**Application:** DC/26/00298  
**Location:** EcoPower Suffolk Solar Project  
**Proposal:** Consultation on Application received by the Planning Inspectorate - Scoping Opinion for the EcoPower Suffolk Solar project

**Ecopower Suffolk Solar – BMSDC: EIA Scoping Report | Reference: DC/26/00298**

**Environmental Impact Assessment Scoping Report Reference: 302827-00/EIASR Issue P01 (23rd January 2026)**

Role
Scoping Report

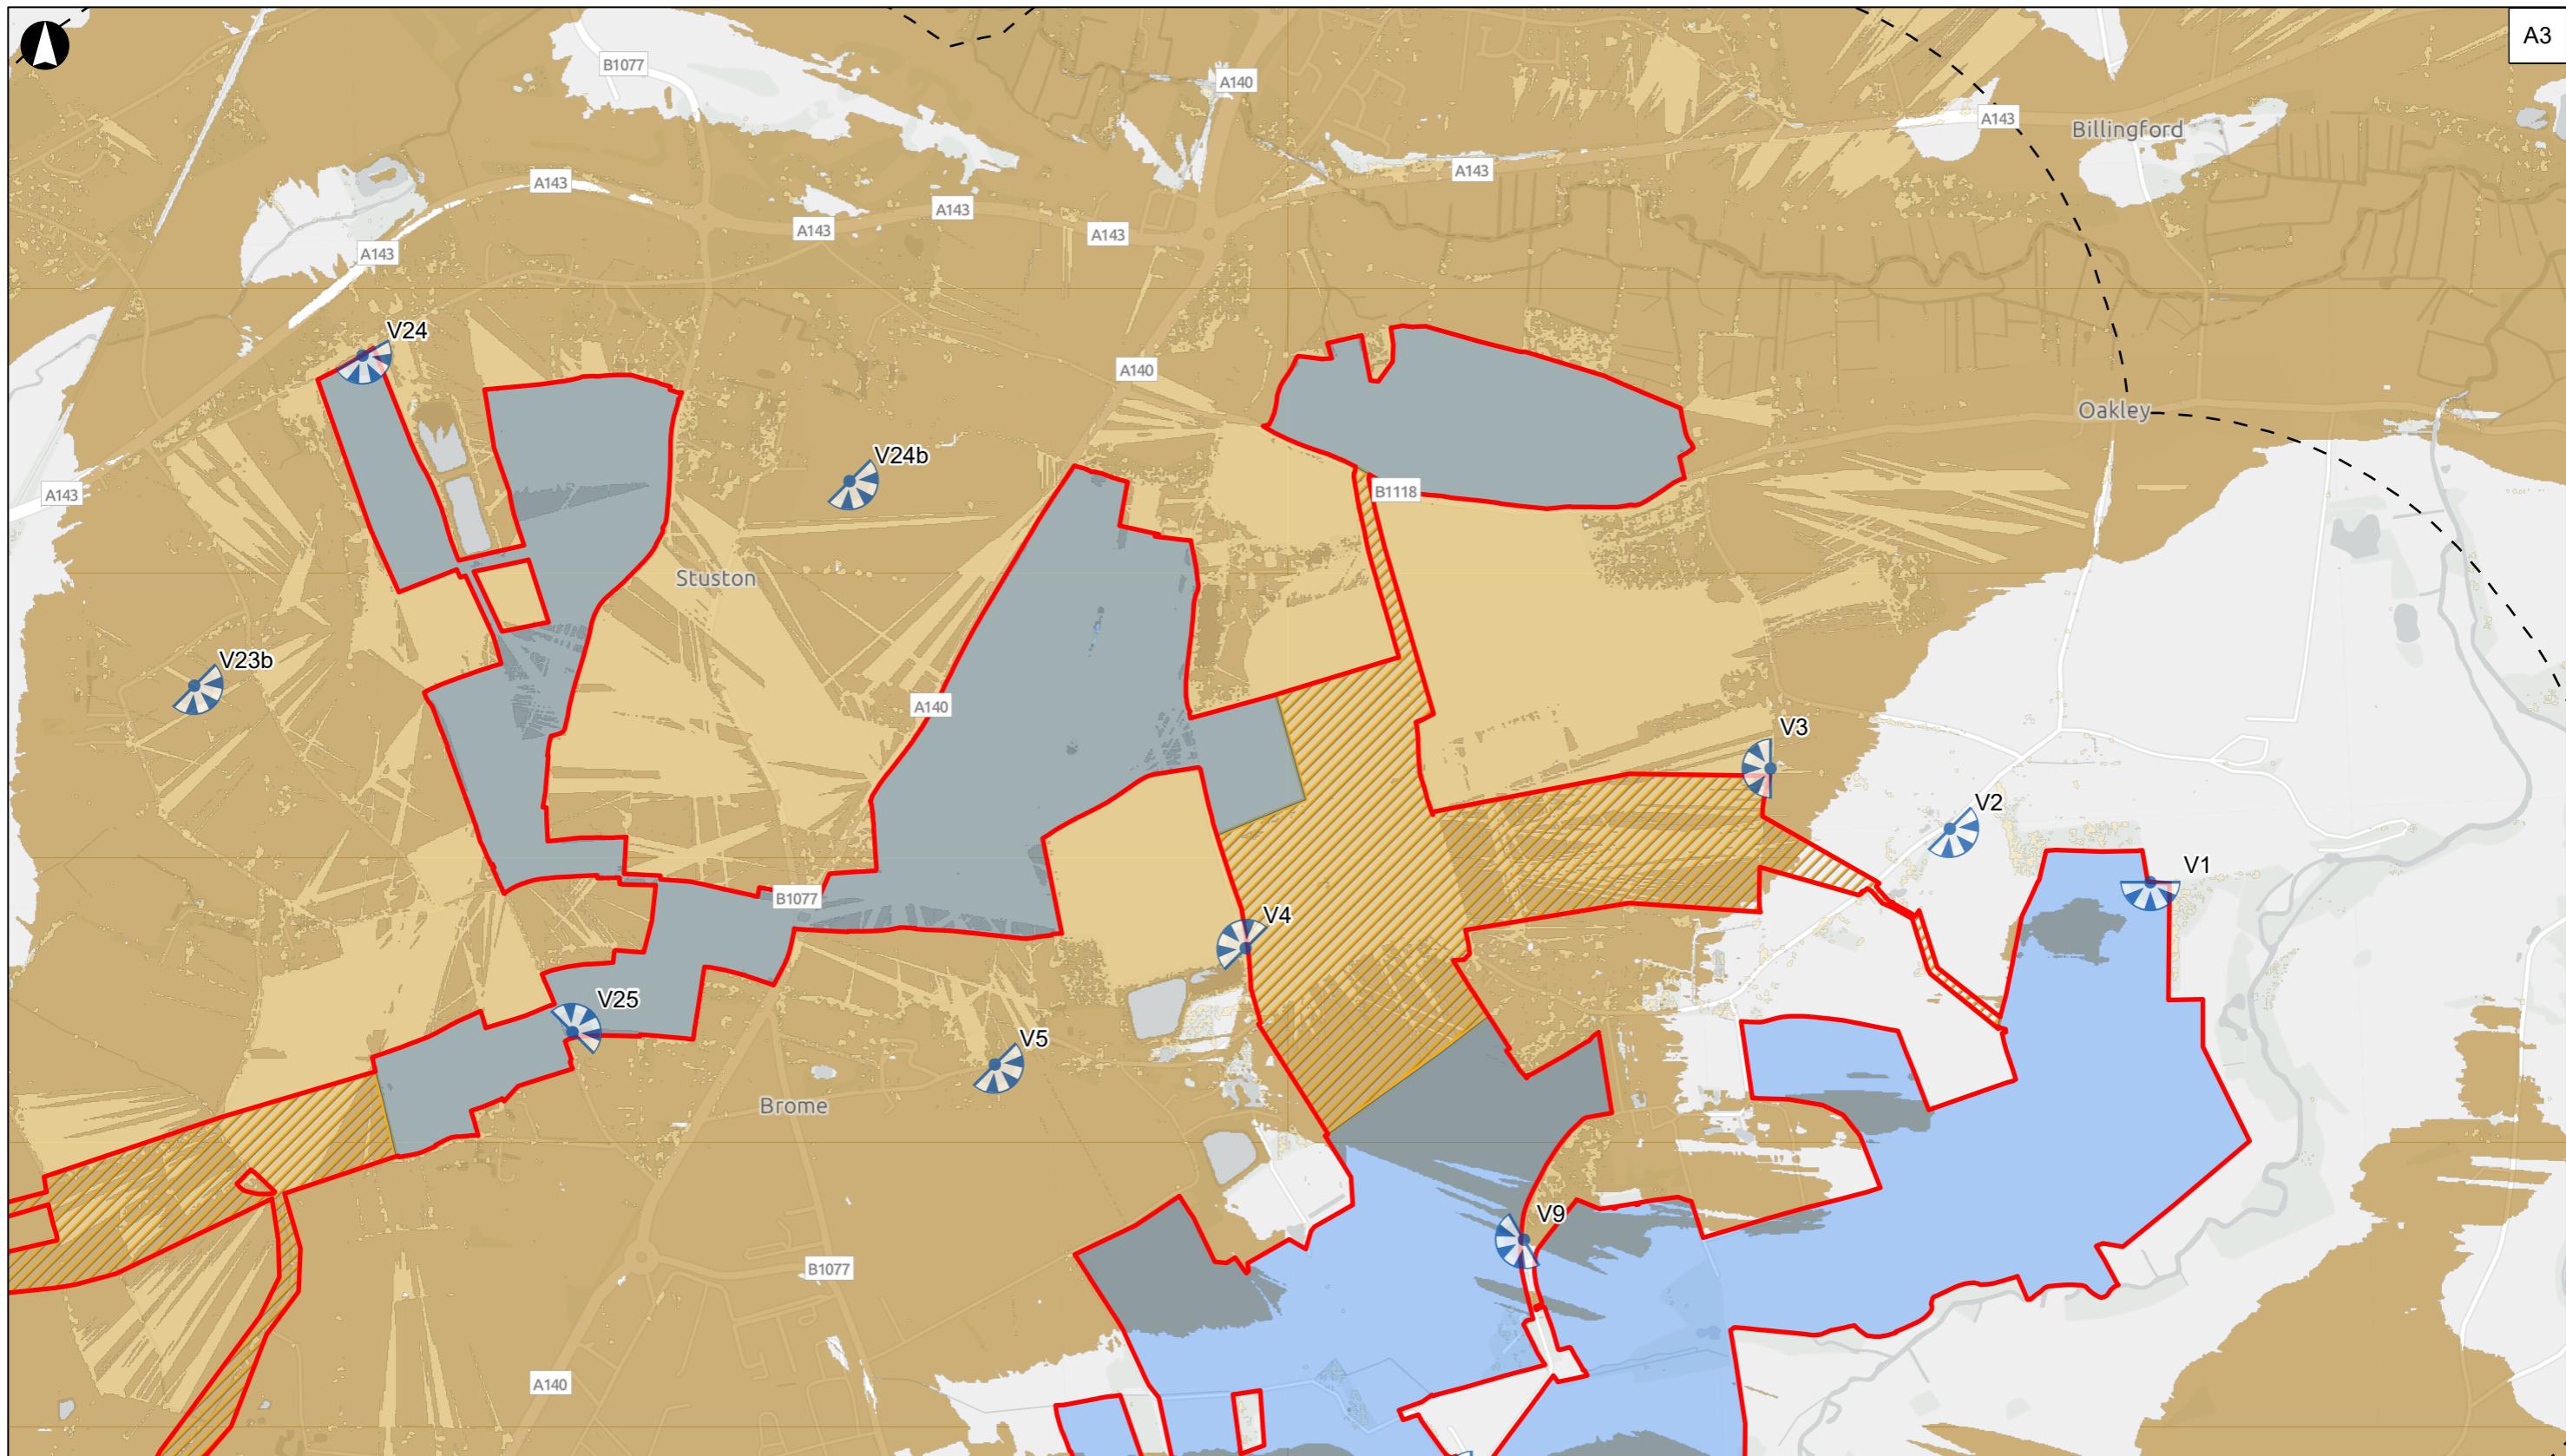
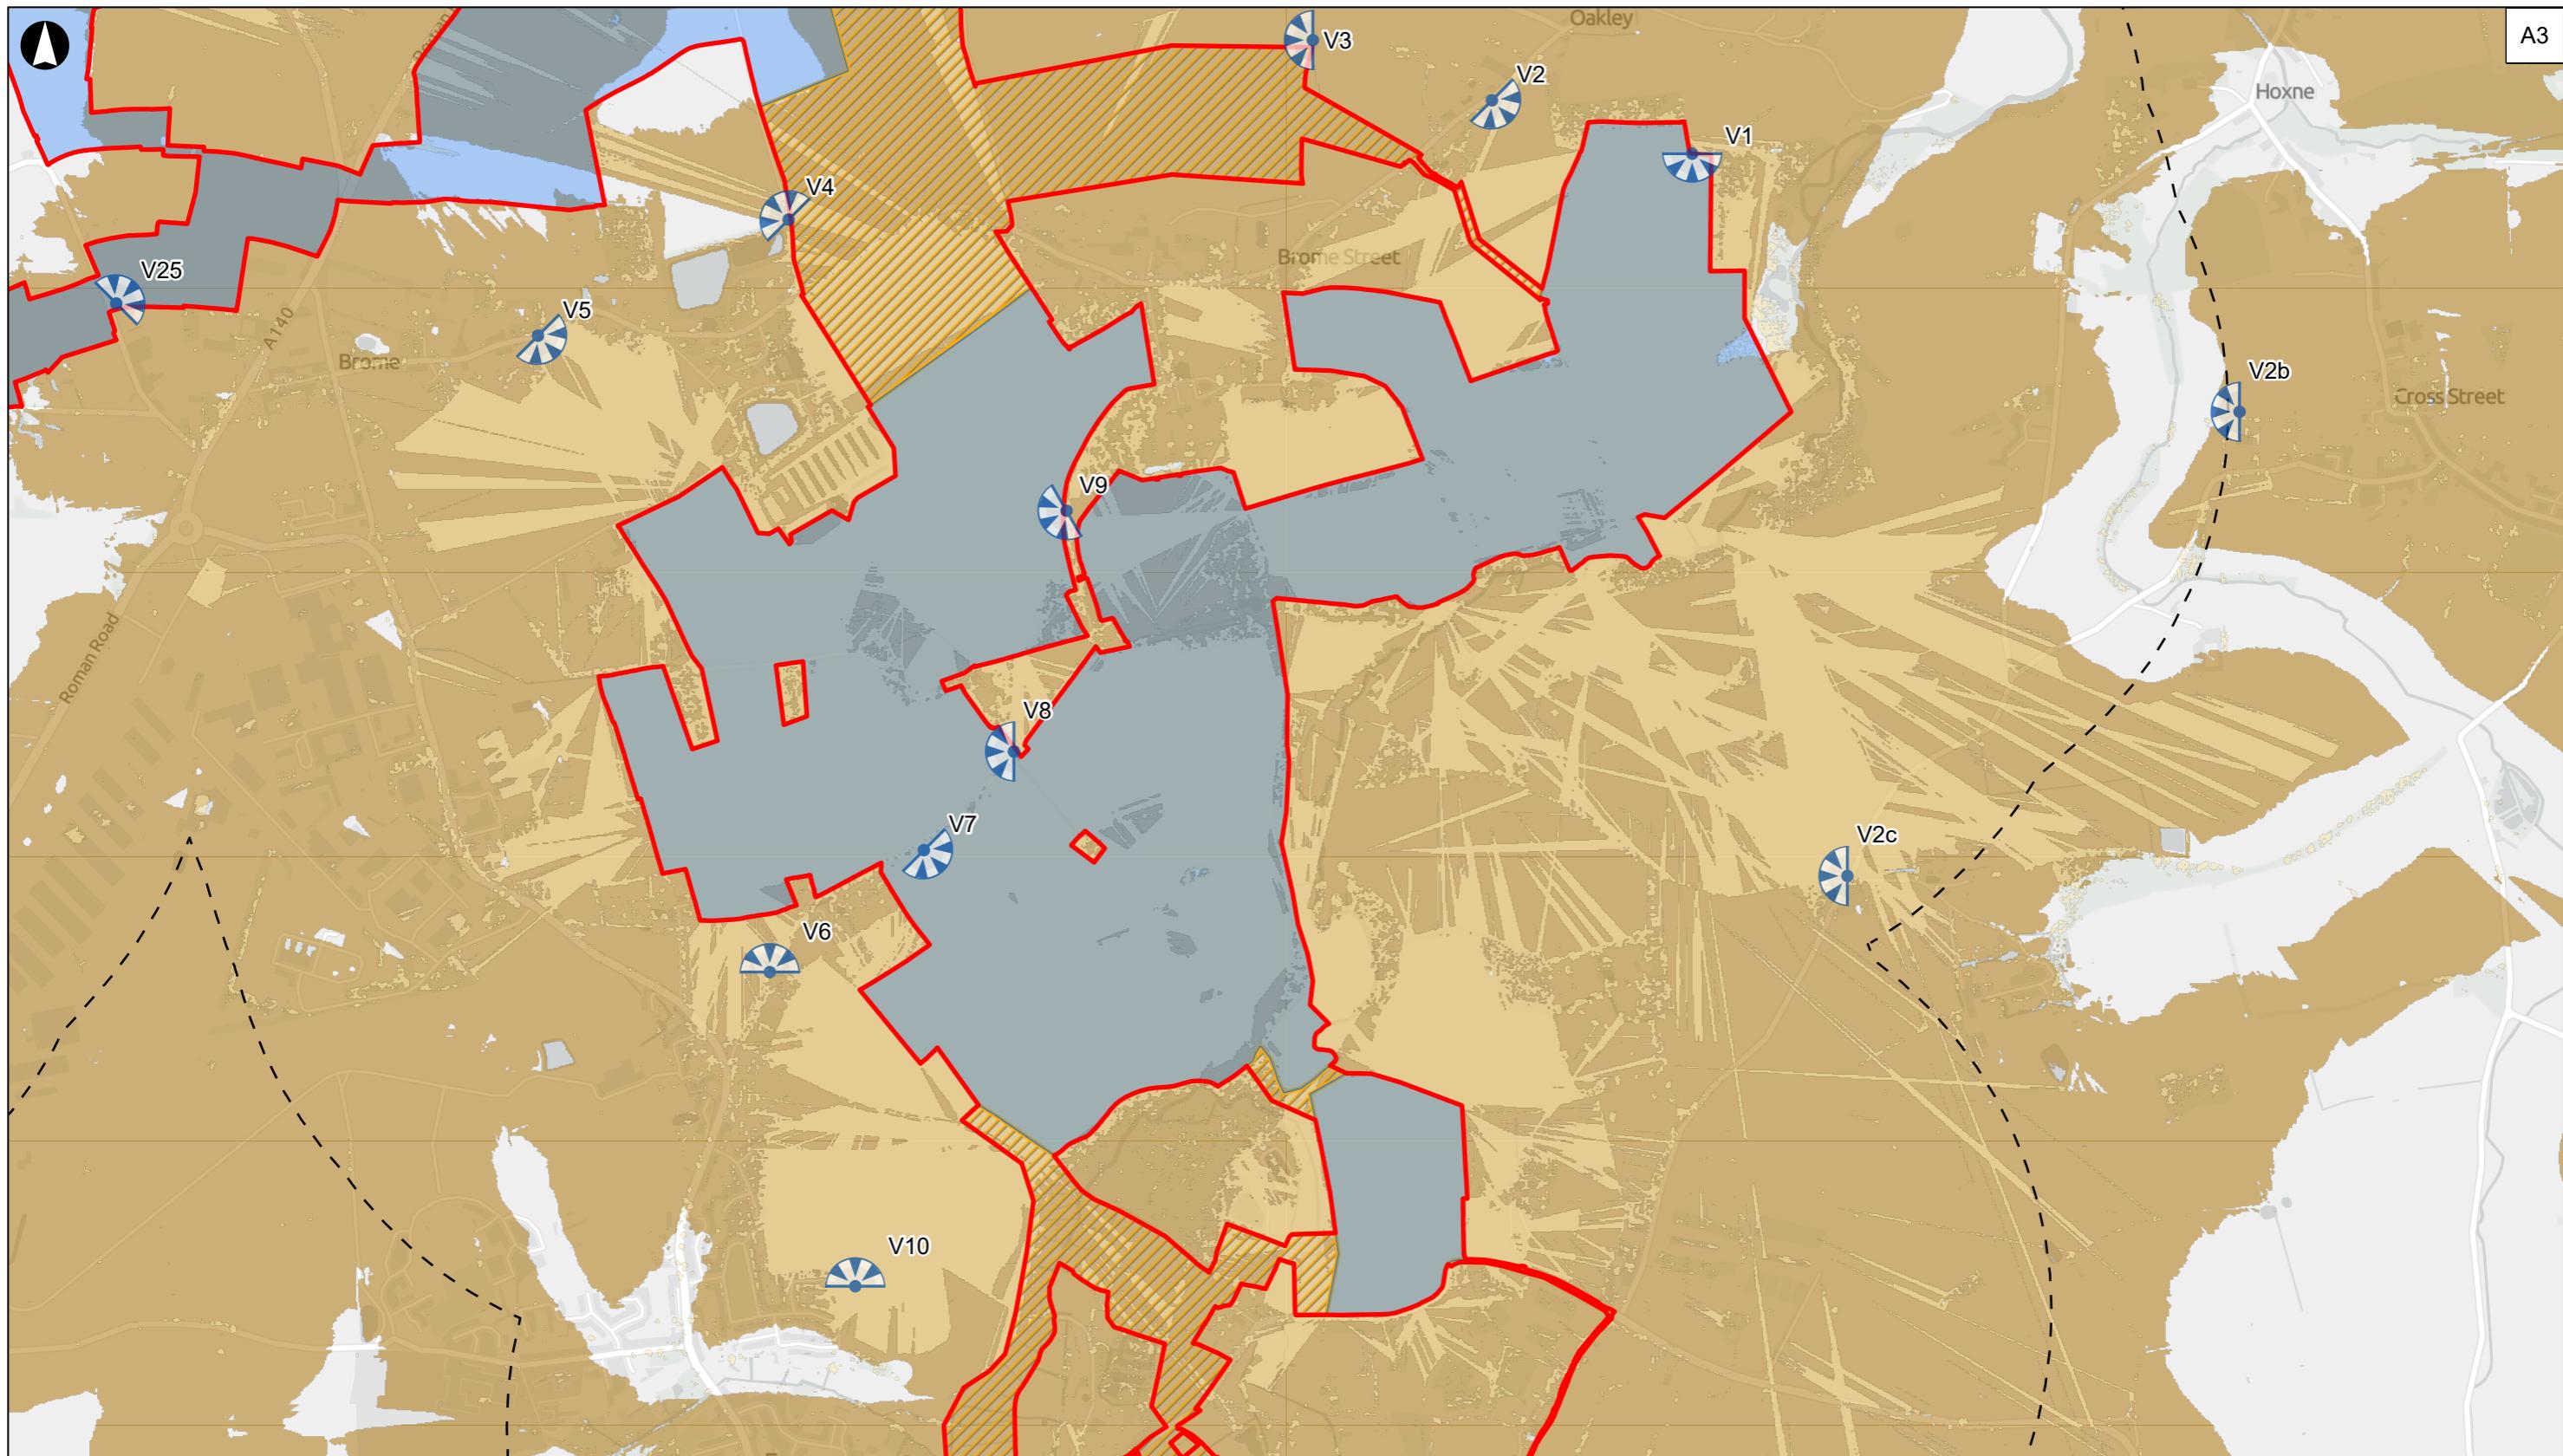
and we support the suggested criteria including consideration of physical and historic connectivity and relationships with other sites and the wider landscape as well as the Proposed Development's Zone of Theoretical Visibility which is shown in Figure 7.8. We note further that it is anticipated that Scheduled Monuments and Grade I and Grade II\* listed buildings located within the Study Area and within the ZTV are considered likely to be the most sensitive to changes within their setting based on the EIA methodology (though what value/sensitivity is to be assigned to these assets has not yet been set out).

- 1.11. We note the proposed viewpoint locations and directions shown on Figure 7.8 but consider that there should be additional viewpoints and visualisations to specifically inform the assessment of impact on the setting and significance of heritage assets.

- 1.12. Views looking towards and out from Mellis Conservation Area would be a key priority due to the proximity to Area 3 Gislingham and Area 5 Thrandeston and Mellis, including views from and towards the listed buildings located at the western end of the Conservation Area:

- Grade II Marsh Farmhouse (List entry number 1032768) – located to the north-west of Area 5 Thrandeston and Mellis
- 1.15. Further viewpoints and visualisations should be provided looking out from and towards the Thrandeston Conservation Area which is located to the east of Area 5 Thrandeston and Mellis. The following listed buildings are located at the western edge of the Conservation Area for which viewpoints and visualisations should be provided:
